From : Mr. and Mrs. D. E. Hurt
19B River Road, Arundel, BN18 9EY

Ref. planning application AB/87/13 [13473/02] (formerly AB/43/13)
Extension to No. 19A River Road

13473/ 02

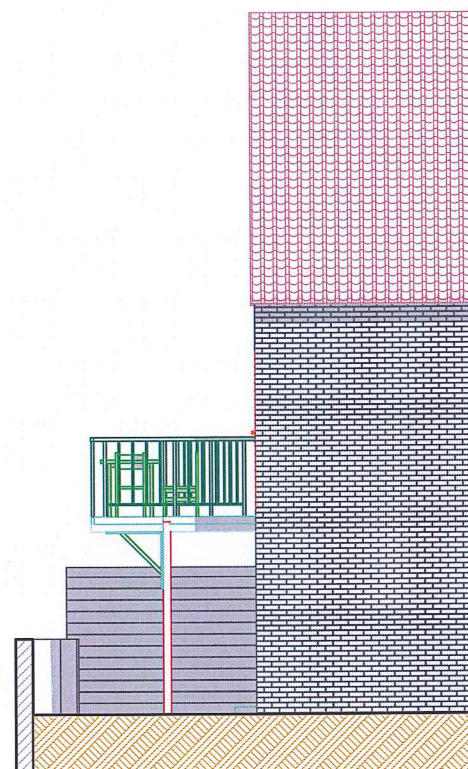
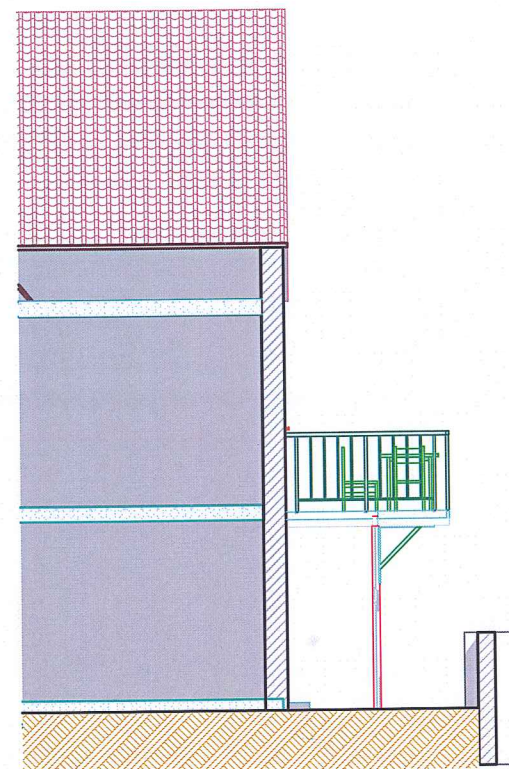
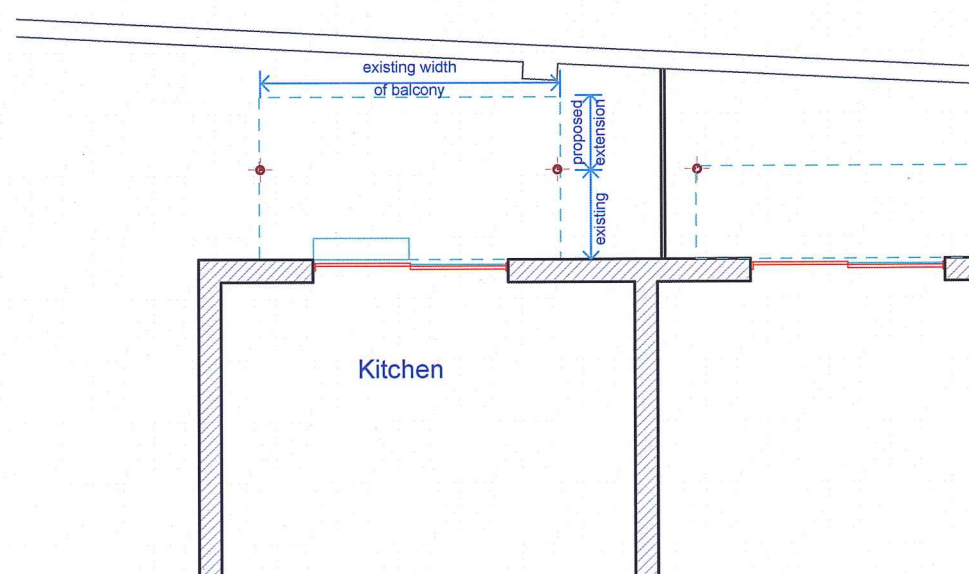
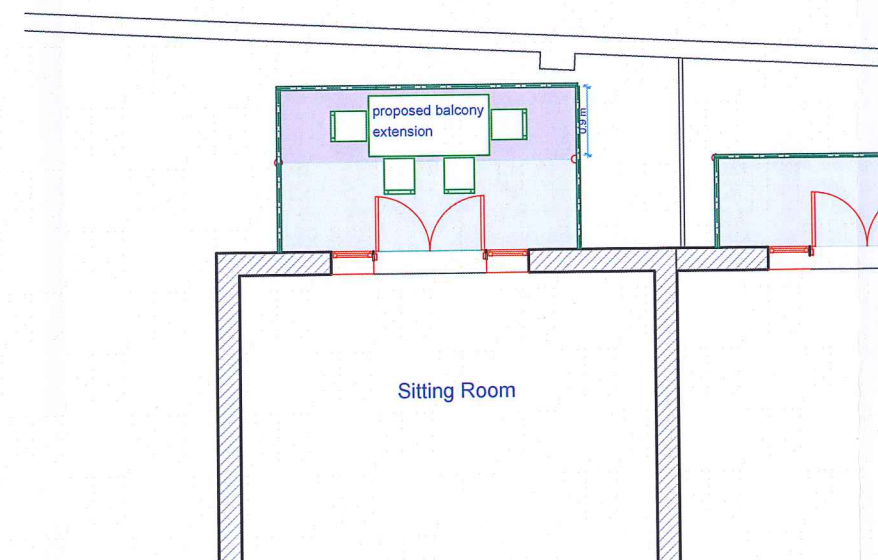
Privacy. Existing balconies on these three properties [19A, 19B, 19C] only provide views up and down river and across river, and do not allow a line of sight into next-door rooms, whereas this extension will do so.

It will change the appearance of the south side [river] view of these three properties. They were constructed to give a unity of design and appearance. The size of the extended balcony will break this unity.

We also raised the question as to whether the extra weight could affect the stability of the earth fill-in below the terraces and the river wall. Any such instability could affect the terrace and river wall of a neighbouring property.

We did also query the choice of glass surround for the balcony; however, this glass does not appear to be part of the new plans.
